**Fort Street Public School (SSD-10340)
Response to Submissions**

ATTACHMENT 1

Landscape Soil Depth Ground Plan

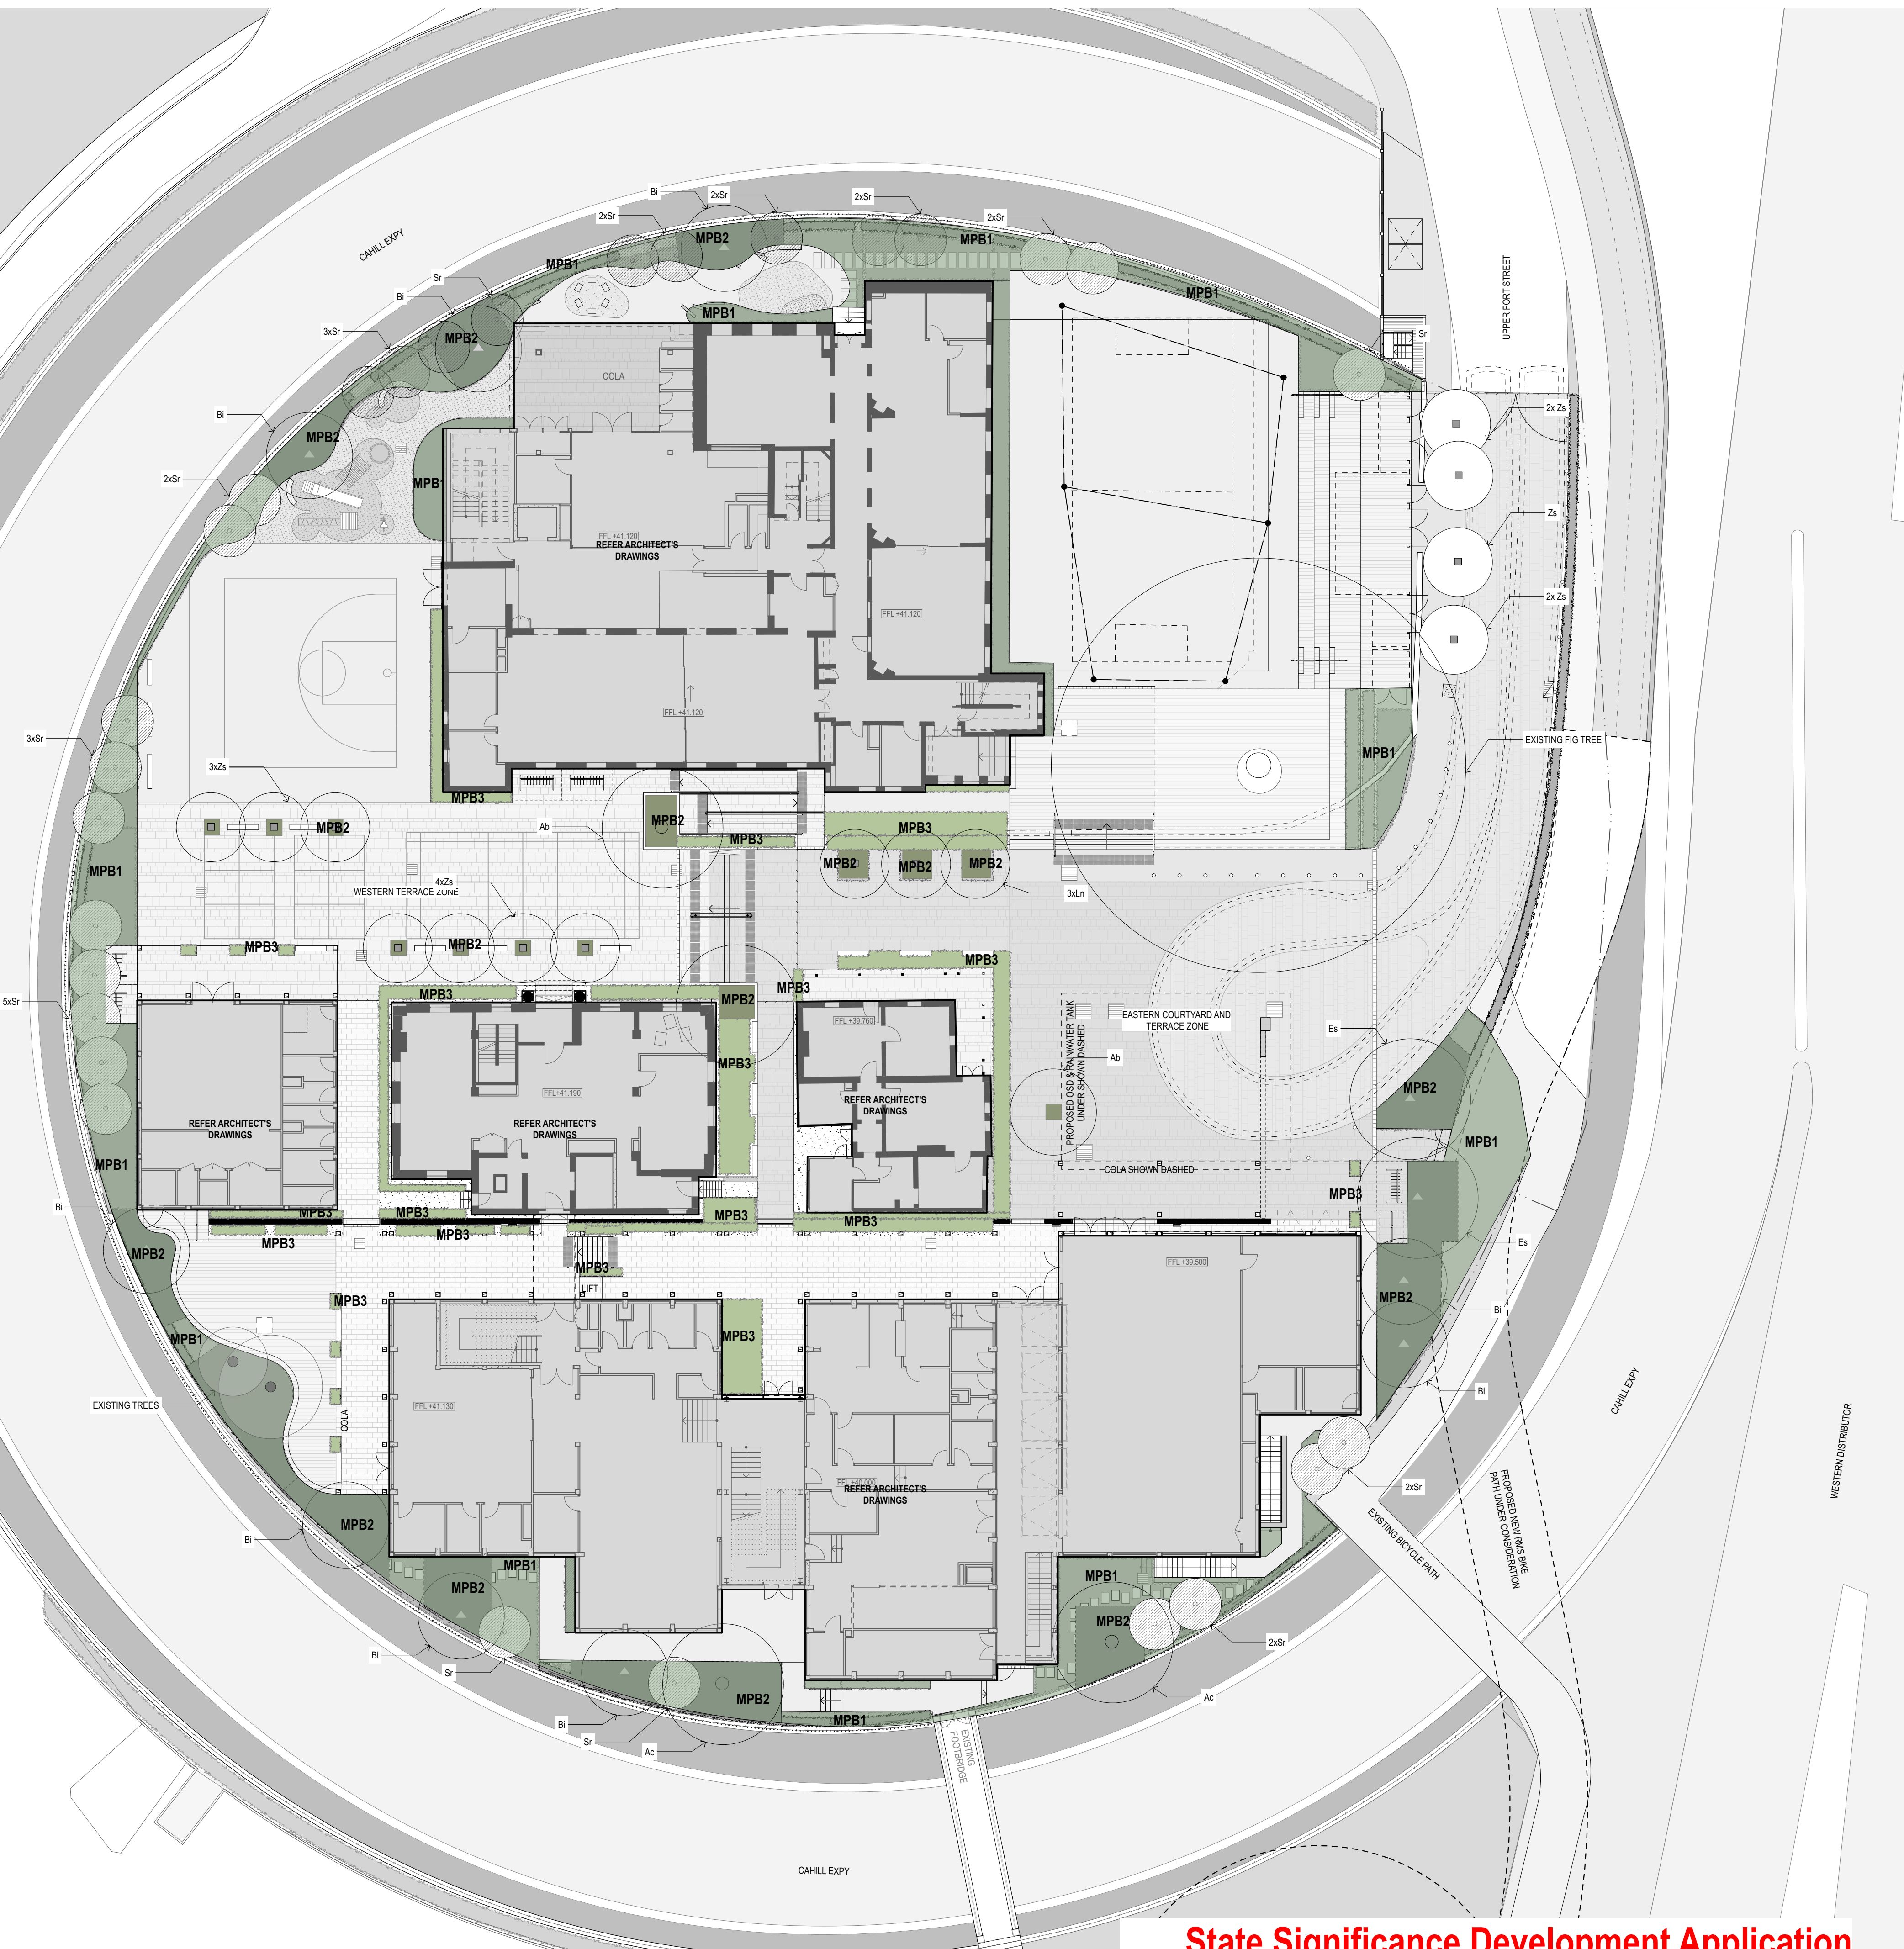
It is noted that there is a planting schedule in the landscape report. However, it is not clear how this planting schedule corresponds to the submitted landscape plans. The planting schedule is to be incorporated within the landscape plans.
